CTC Bognor Regis and Chichester Part of Cycling UK

Re Pagham P/140/16/OUT Land South of Summer Lane & West of Pagham Road Pagham

I write to make formal objection on behalf of my organisation to this application. Although there are many reasons for objection which have been dealt with in other comments I will confine this letter to issues relating to the safe use of bicycles in the area both by our members and other residents in the local area especially Aldwick, Rose Green, Nyetimber and Pagham.

Figure 5.4 – Link to Pagham Harbour cycle route

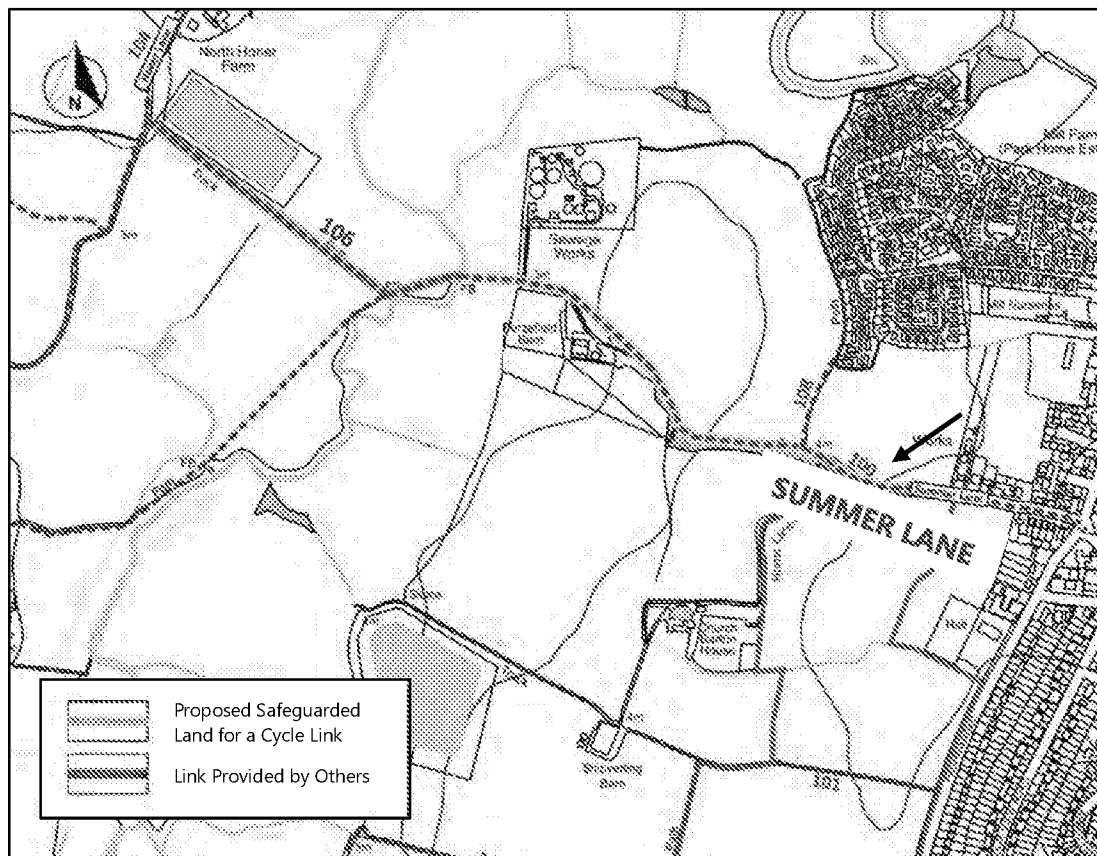
The Transport Assessment December 2016 includes on Page 8 at Para 1.4 that the (application) proposal is to provide

Viii The safeguarding of land to help link to the existing cycle route between Pagham Harbour and Chichester with Pagham Road via the site.

The site ownership boundary Plan and the Plan showing the proposed Cycle link indicate that the Applicants own or have control of Summer Lane and the small field crossed by the existing footpath as far as the Rife. The next field as far as Honer Lane is owned by others.

Regardless of any S106 agreement there should as a minimum be a condition imposed that the applicants, if consent is granted, should upgrade the status of Summer Lane from footpath to Cyclepath and fund the paving to cyclepath standard of the footpath from the end of Summer

Lane to the Bridge over the Rife. This to be independent of any arrangements or progress on the balance of the cycle route.
